**OXFORDSHIRE COUNTY COUNCIL'S RESPONSE TO CONSULTATION ON THE
FOLLOWING DEVELOPMENT PROPOSAL**

Application no: 14/01830/REM

Proposal: Reserved matter – (Outline application 05/01337/OUT) – Details for the proposed sports changing pavilion adjacent to the sports pitches, including 29 associated car parking spaces and 2 coaches bays.

Location: Sport Pavilion land off Bankside Adjacent Longford Park Road, Bodicote

Org. no 1419 | 500 | Rev A

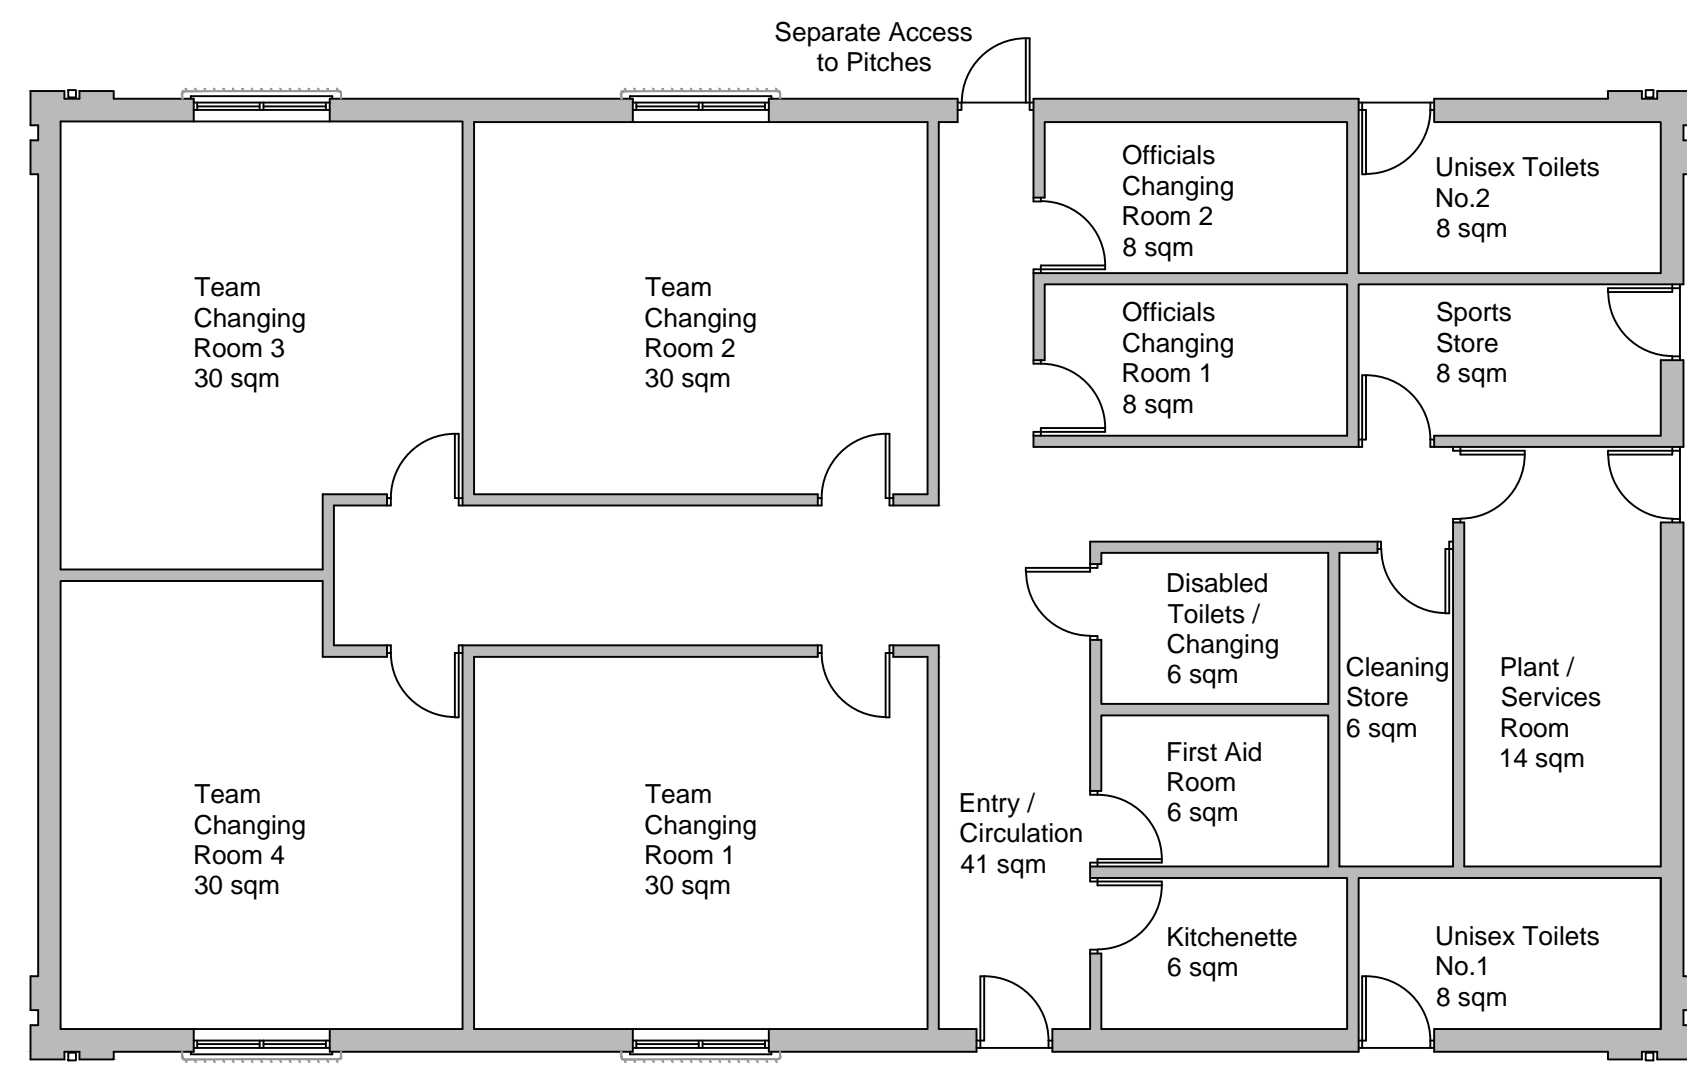
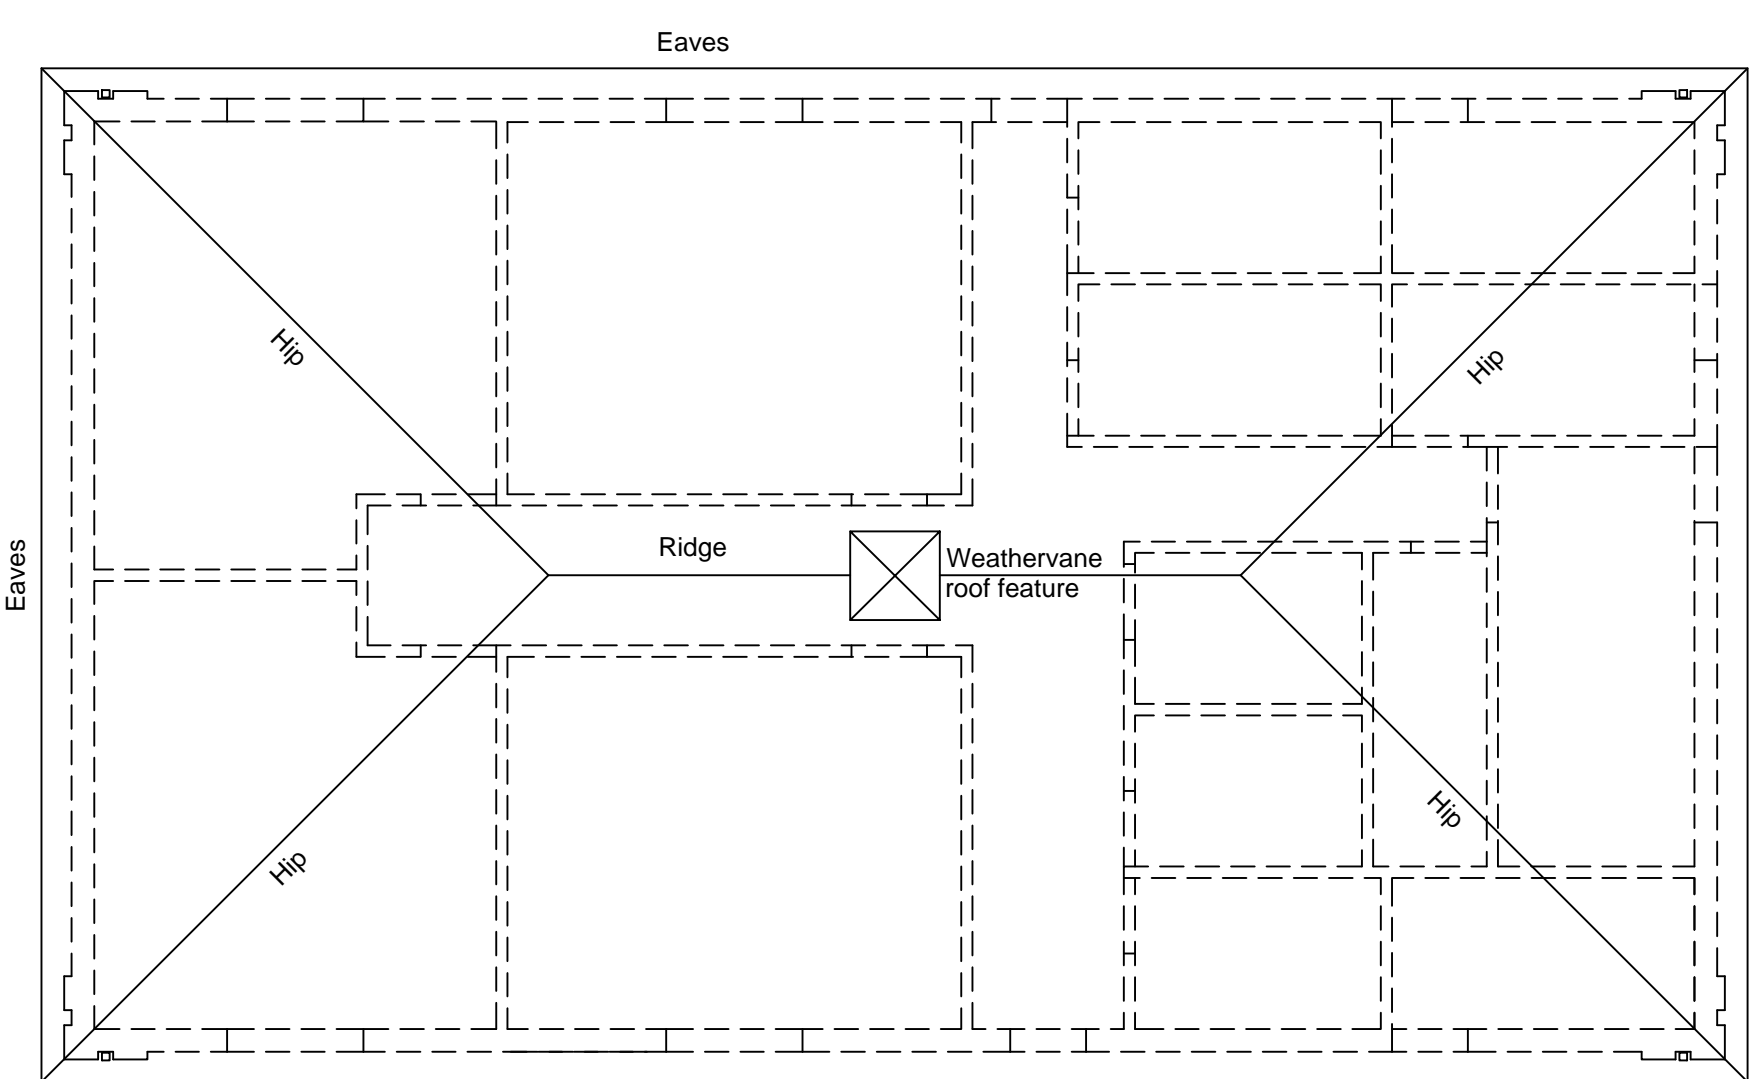
- No Cycle parking has been demonstrated on the supplied plans; this will need to comply with standards in terms of number of spaces, covered/secure, located as close to the main entrance to the building as possible and use 'Sheffield' type cycle stands.
- The Highway Authority has concerns regarding the proposed coach parking arrangement and there is likely access/egress issues – vehicle tracking will need to be supplied
- No refuse storage has been demonstrated, furthermore refuse vehicle tracking will need to be submitted
